Application Ref:	3/2020/1061	 Ribble Valley Borough Council www.ribblevalley.gov.uk	
Date Inspected:	12/02/2021		
Officer:	AB		
DELEGATED ITEM FILE REPORT:		Decision	REFUSED

Development Description:	Proposed erection of a seven-bedroom holiday cottage.
Site Address/Location:	Pendle View Primrose Lane Mellor BB2 7EQ

Title: Proposed Plans and Elevations.

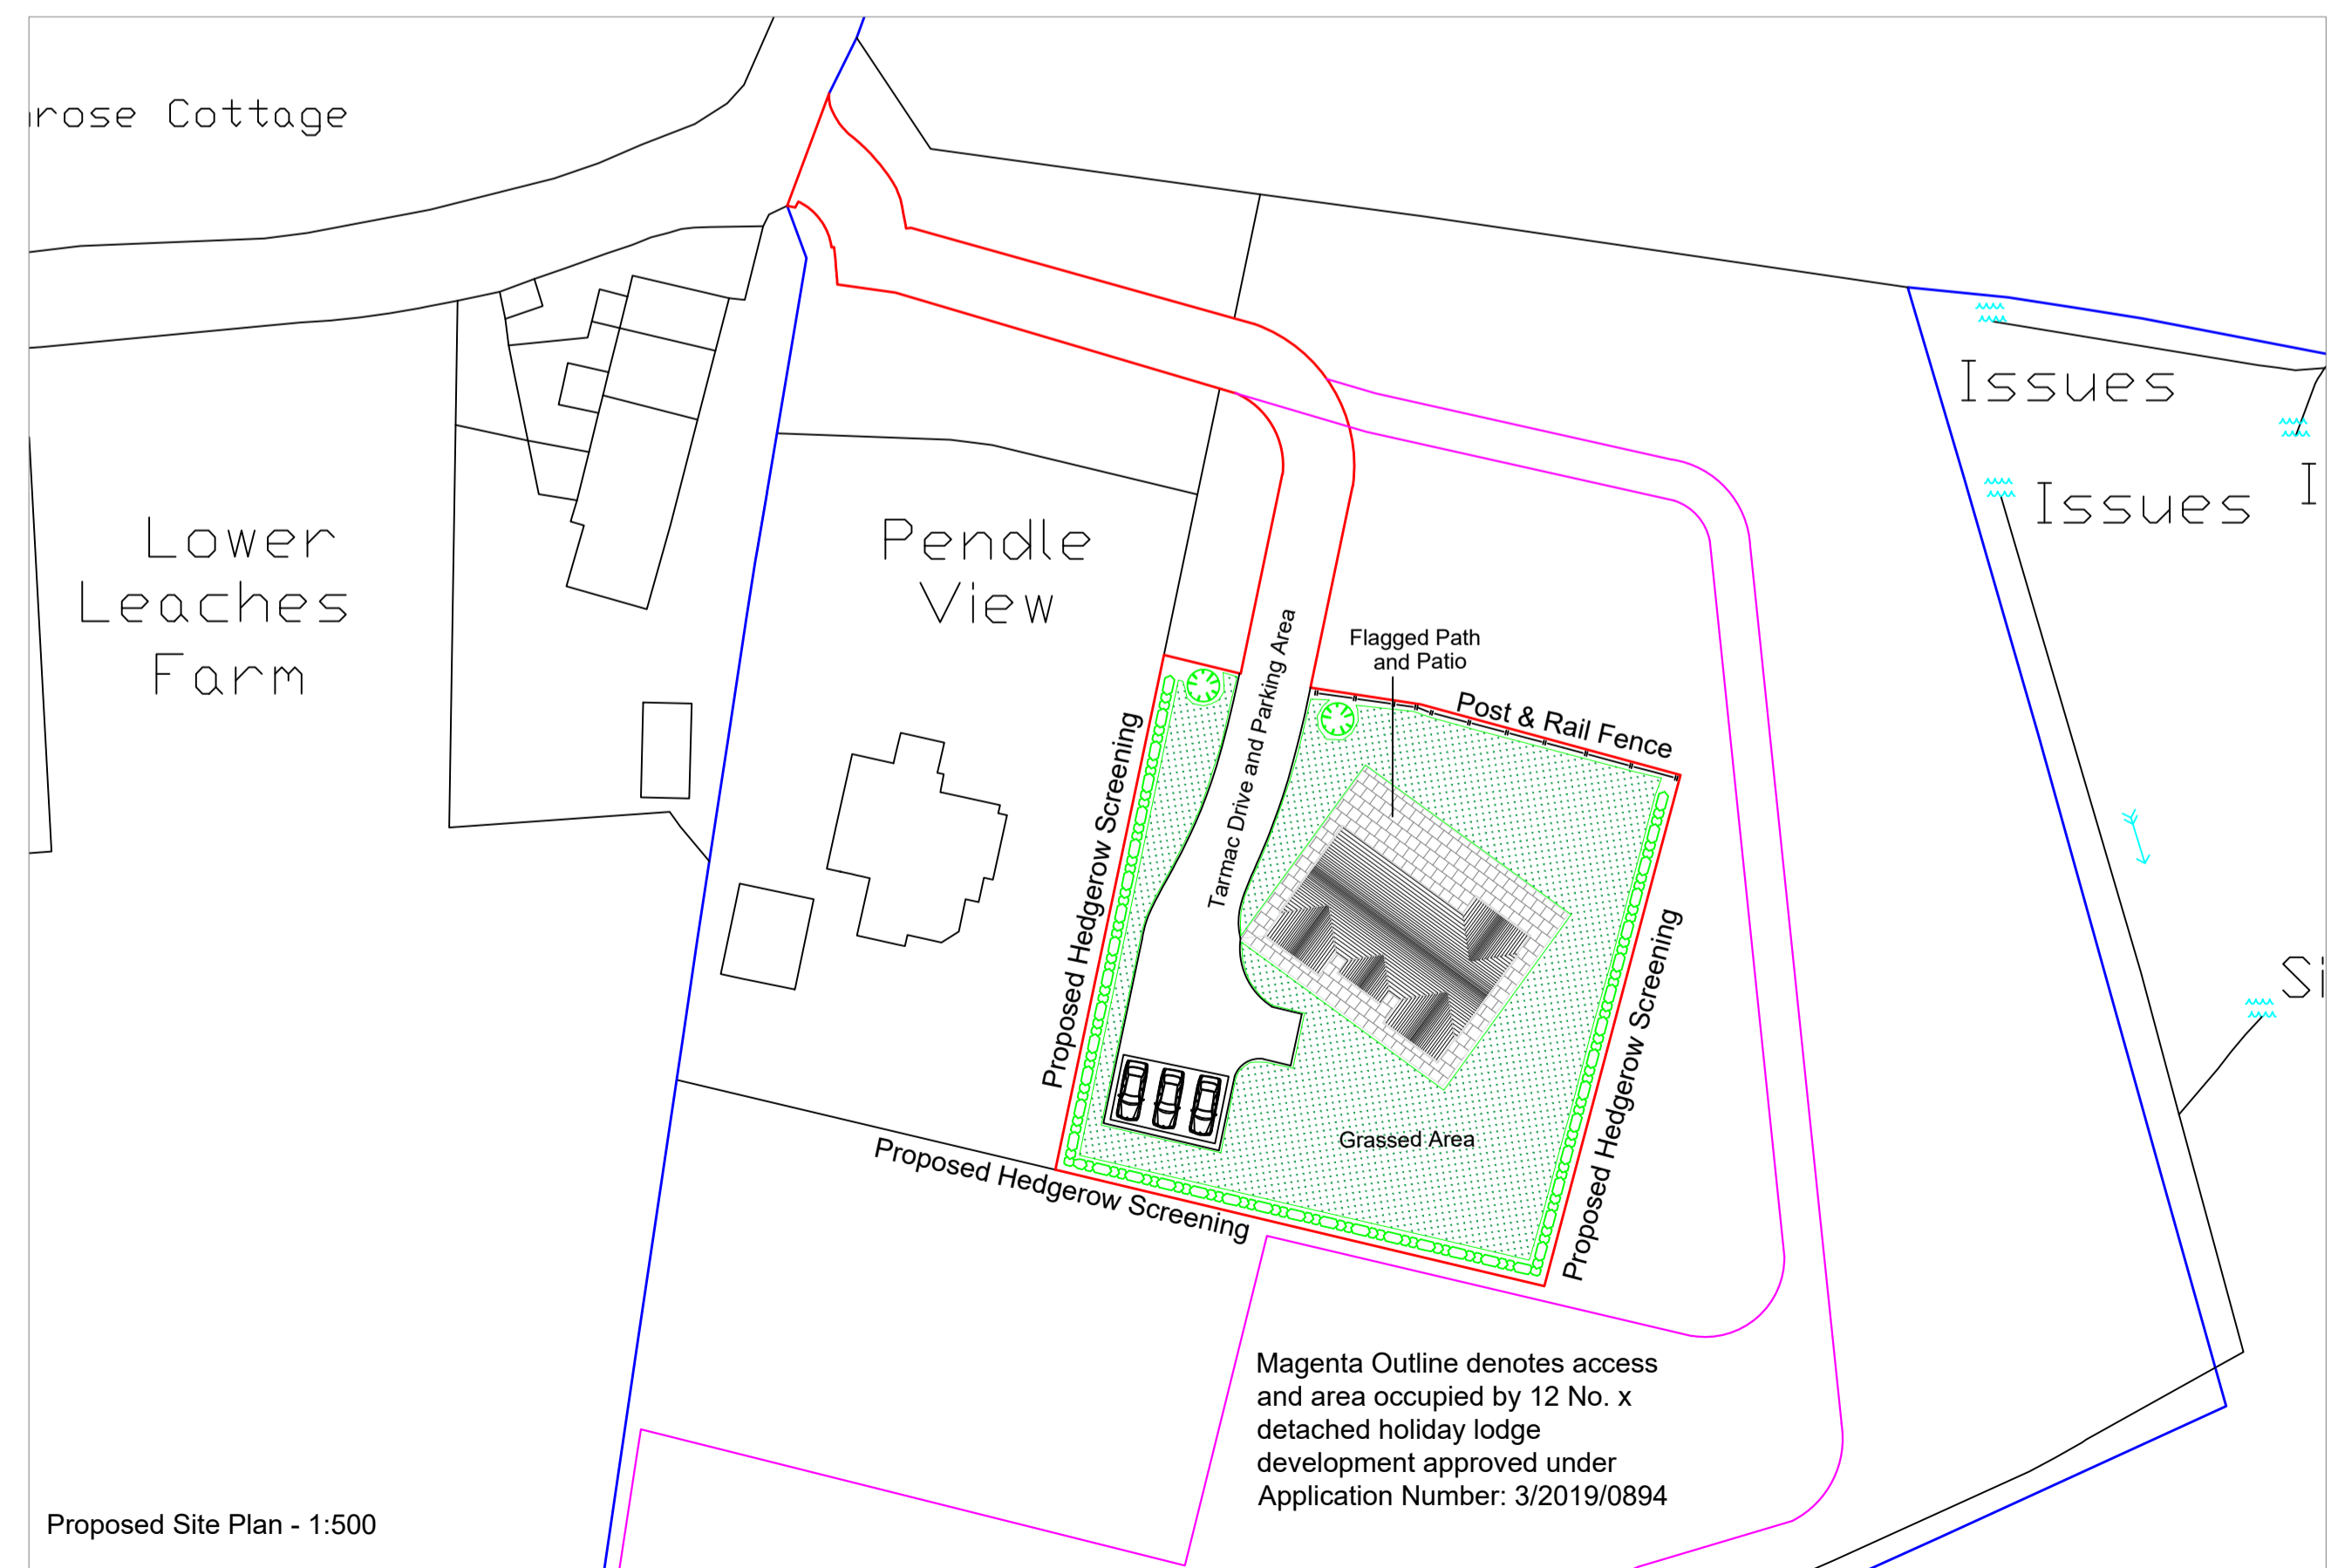
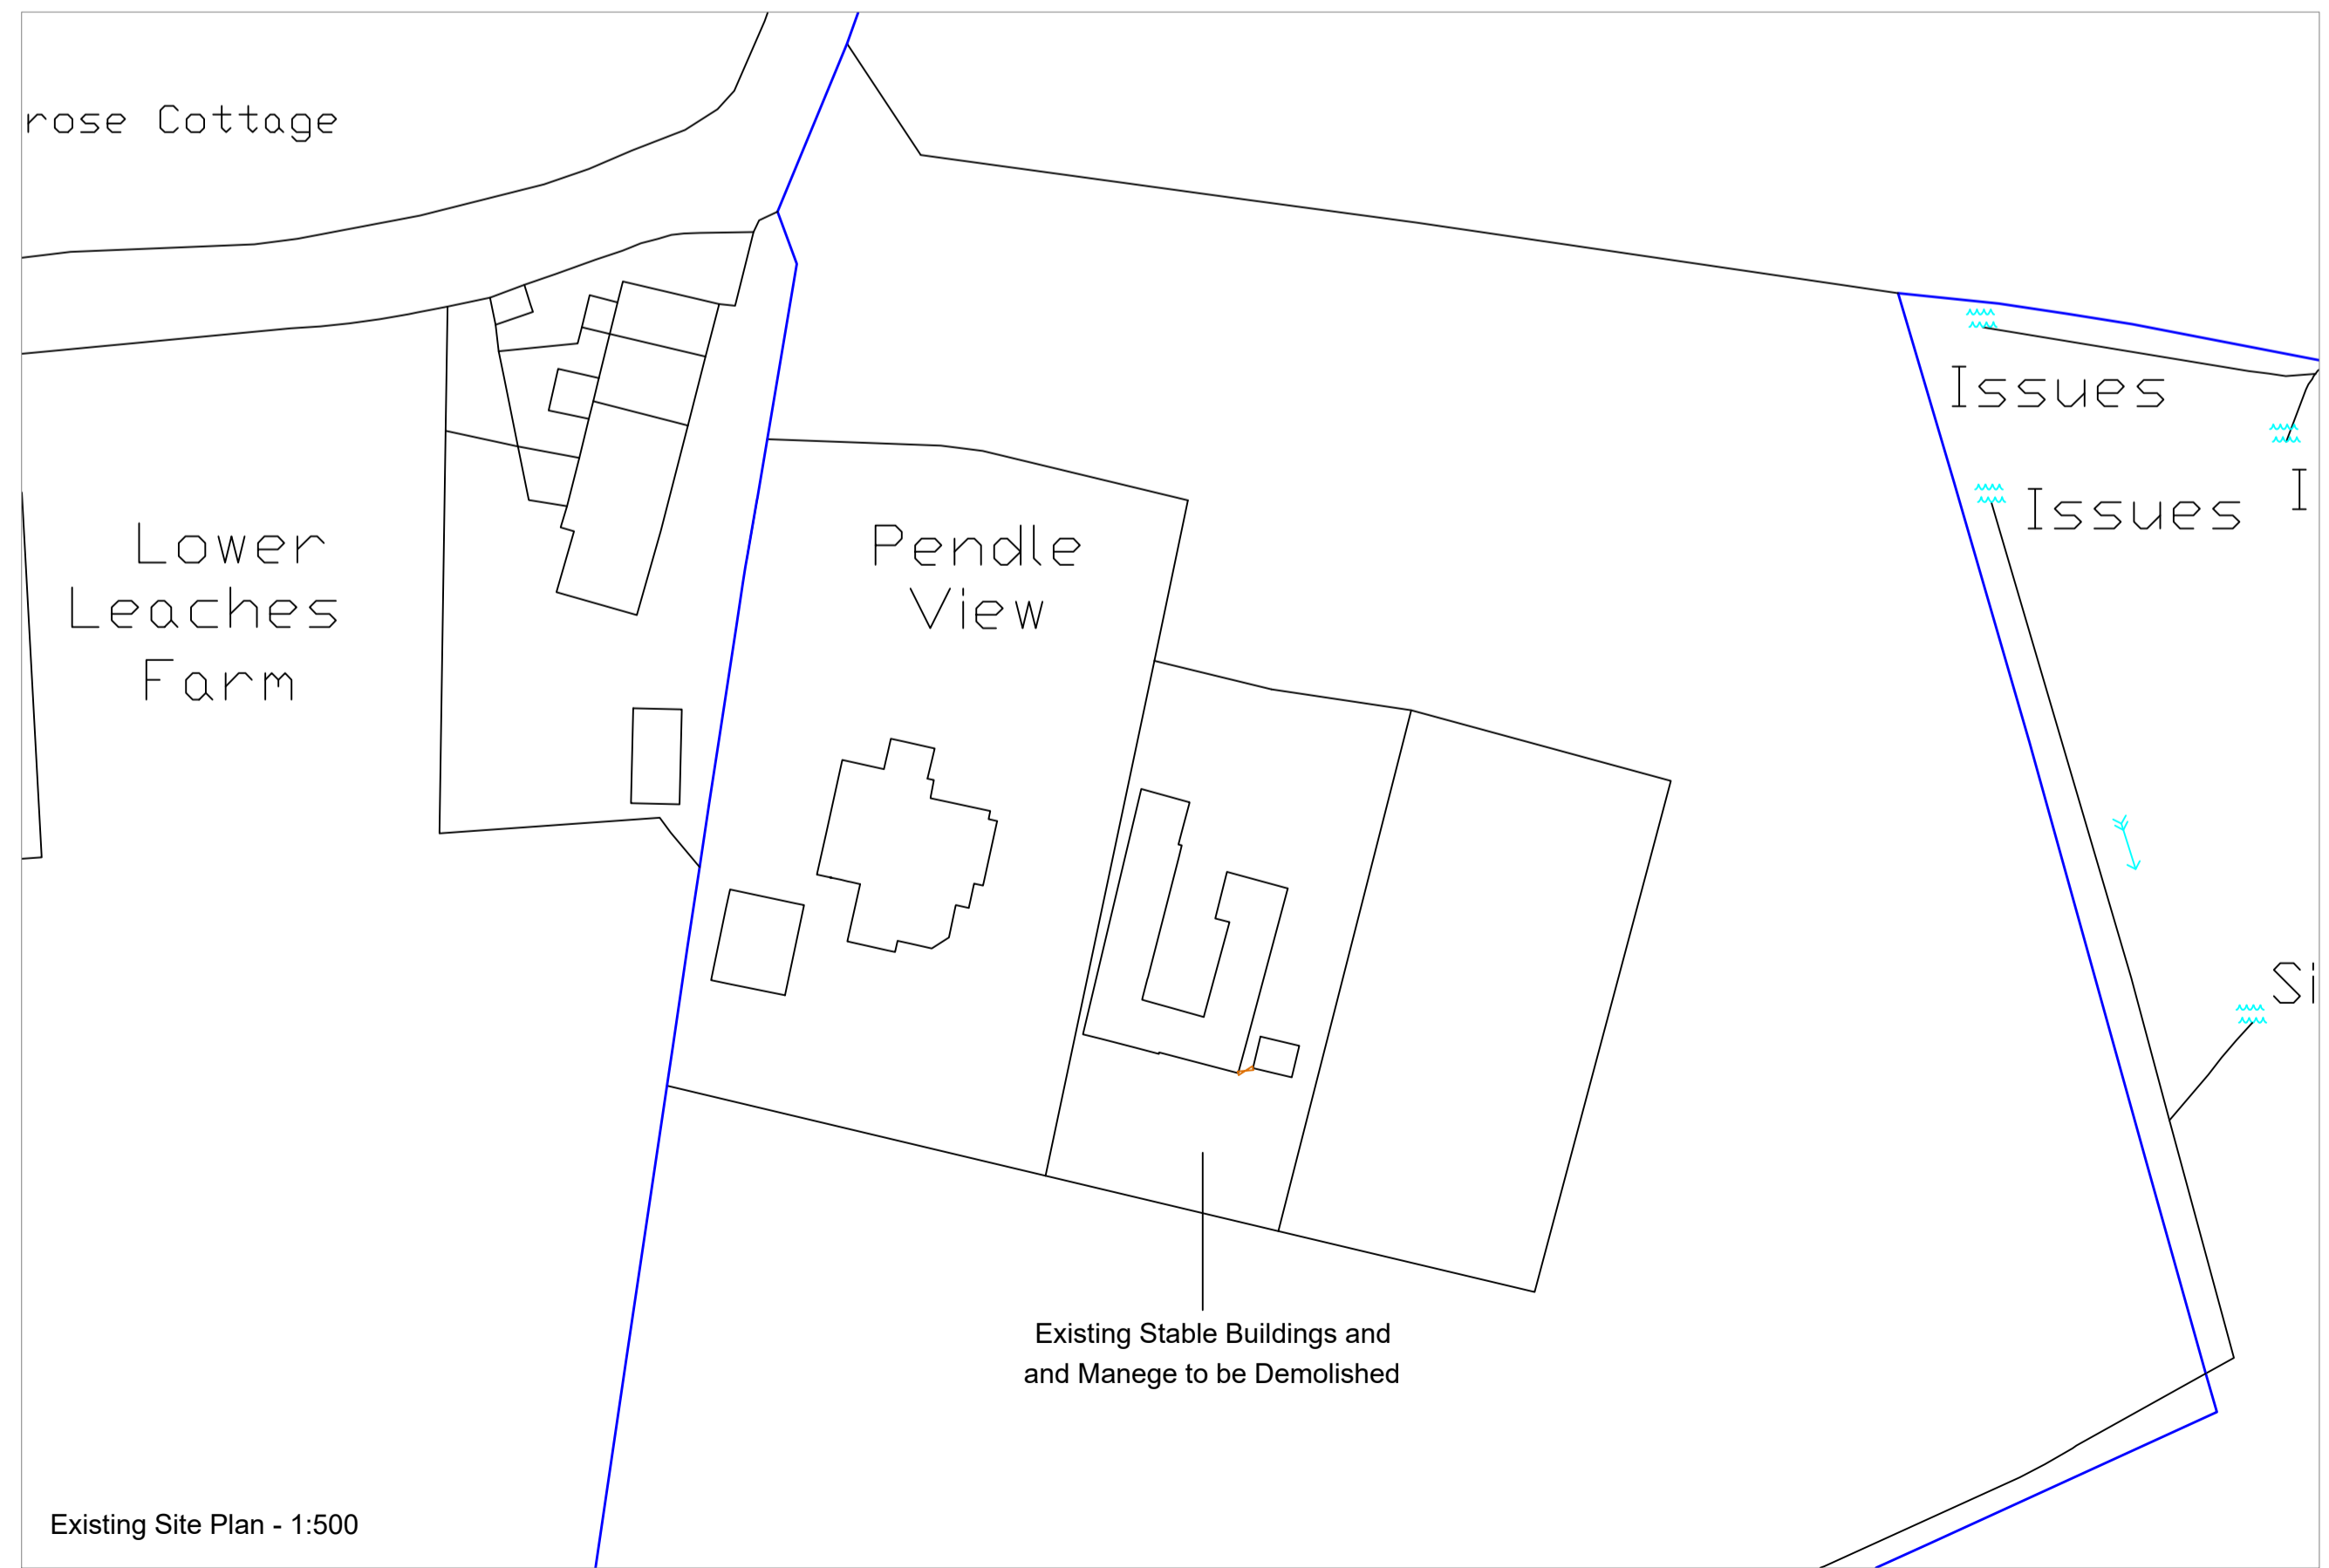
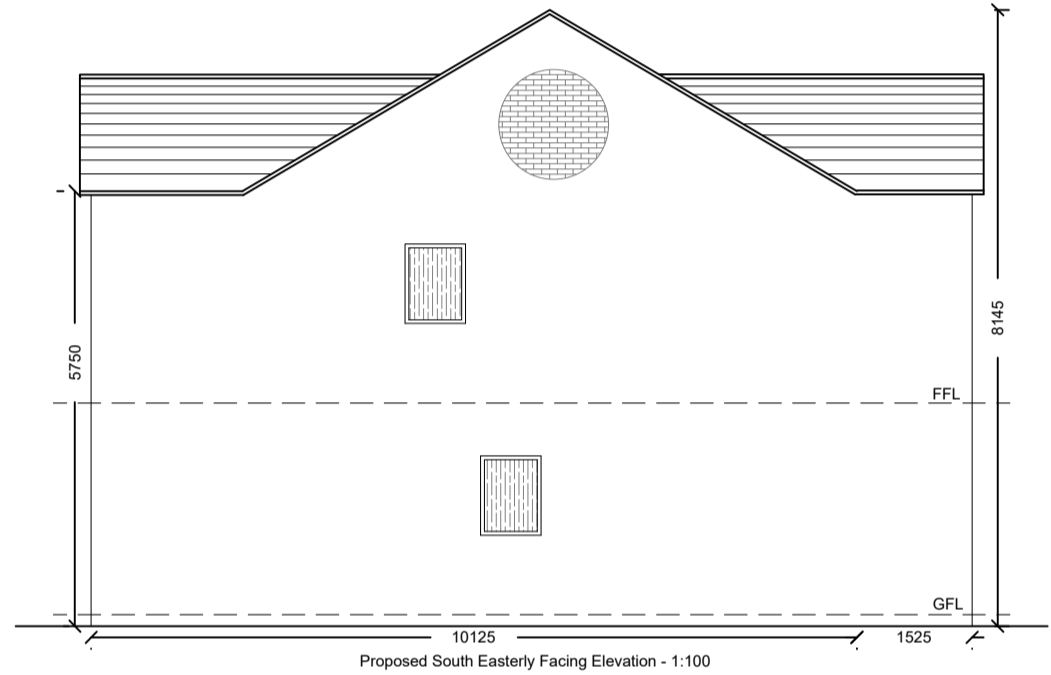
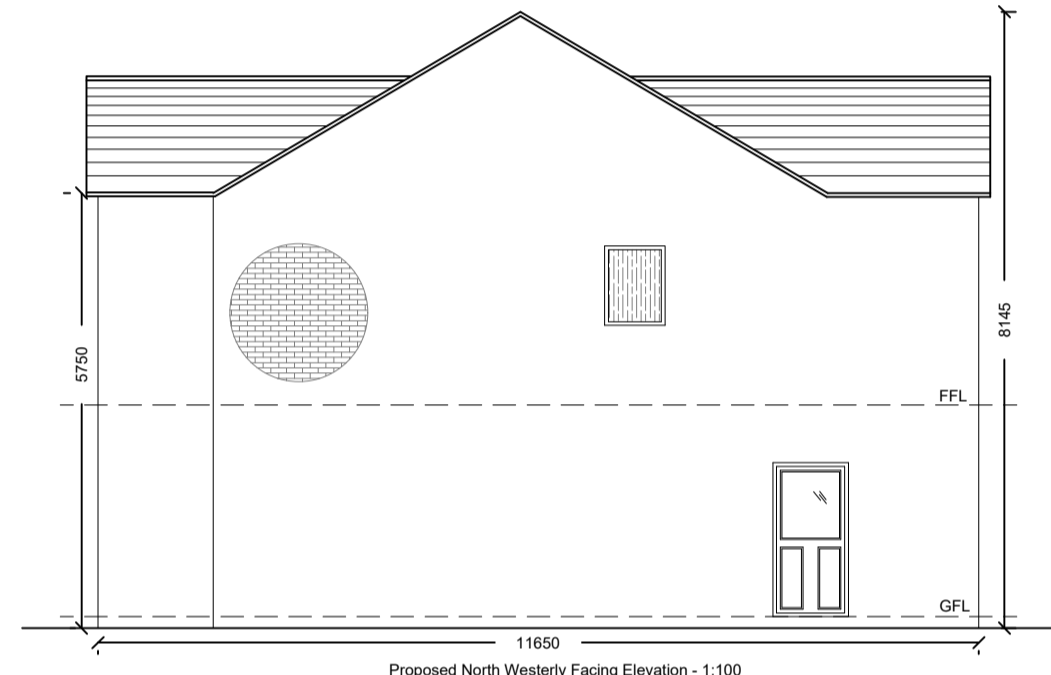
The proposed building would be around 8.2m high to the ridge and would be faced with brick and slate and powder coated aluminium windows and doors. The proposed building would be tilted at an angle compared with Pendle View and would be orientated such that its principal elevation would be south-west facing, opposite the orientation of Pendle View. The principal elevation would have three front-facing gables, the central gable being heavily glazed from ground level to the apex. The rear elevation would have significant glazed elements and would include an external first floor balcony with glass balustrade. The footprint of the building would measure approximately 16 x 12 metres.

With regard to the complex of 12 holiday lodges on land to the rear, it was considered that due to their size and single storey height the development would not result in an unacceptable visual impact. What is proposed in this case is a substantial permanent new two storey building that would be clearly visible from the surrounding roads. The building is proposed to be faced in brick yet the majority of buildings in the immediate area are constructed from natural stone.

In terms of the buildings design, it fails to reflect local vernacular style which includes the use of traditional materials and simple elevational language. The introduction of large glazed elements which includes openings of both vertical and horizontal emphasis and a glazed first floor balcony, results in a poor design and a building that would be a prominent and incongruous addition to this open countryside area.

In addition, the proposals include a generous curtilage area that would be used as garden. This area is significantly larger than would normally be expected for holiday accommodation and would contribute to the harm arising from the scheme as a whole. The site plan indicates the provision of parking for three vehicles. However, the building proposed does not fall into the C3 use class and therefore residential parking standards are not considered applicable in this instance. The County Surveyor (Highways) advises that there is likely to be a requirement to provide up to 7 parking spaces (1 per room) if assessed in a similar way to a hotel for example. The provision of a parking area for up to 7 vehicles would also clearly contribute towards the visual impact of the development but also indicates the potential intensity of the use.

As such, it is considered that, due to the size, scale, design and elevational language of the proposed building, and the extent of garden curtilage proposed, the development would have a considerable negative visual impact and would be contrary to Key Statement EN2 and policies DMG1, DMG2 and DMH3.

1. The proposed development, as a result of its scale and design, would be contrary to Core Strategy Policy DMG2 which requires tourism and recreational developments in the open countryside to be 'small-scale' and 'appropriate to a rural area'.
2. The proposed development, by virtue of its scale, siting, layout and design, would result in an incongruous and prominent addition in this open countryside location that would be harmful to the visual amenity of the area contrary to Key Statement EN2 and Policies DMG1, DMG2 and DMB3 of the Ribble Valley Core Strategy.
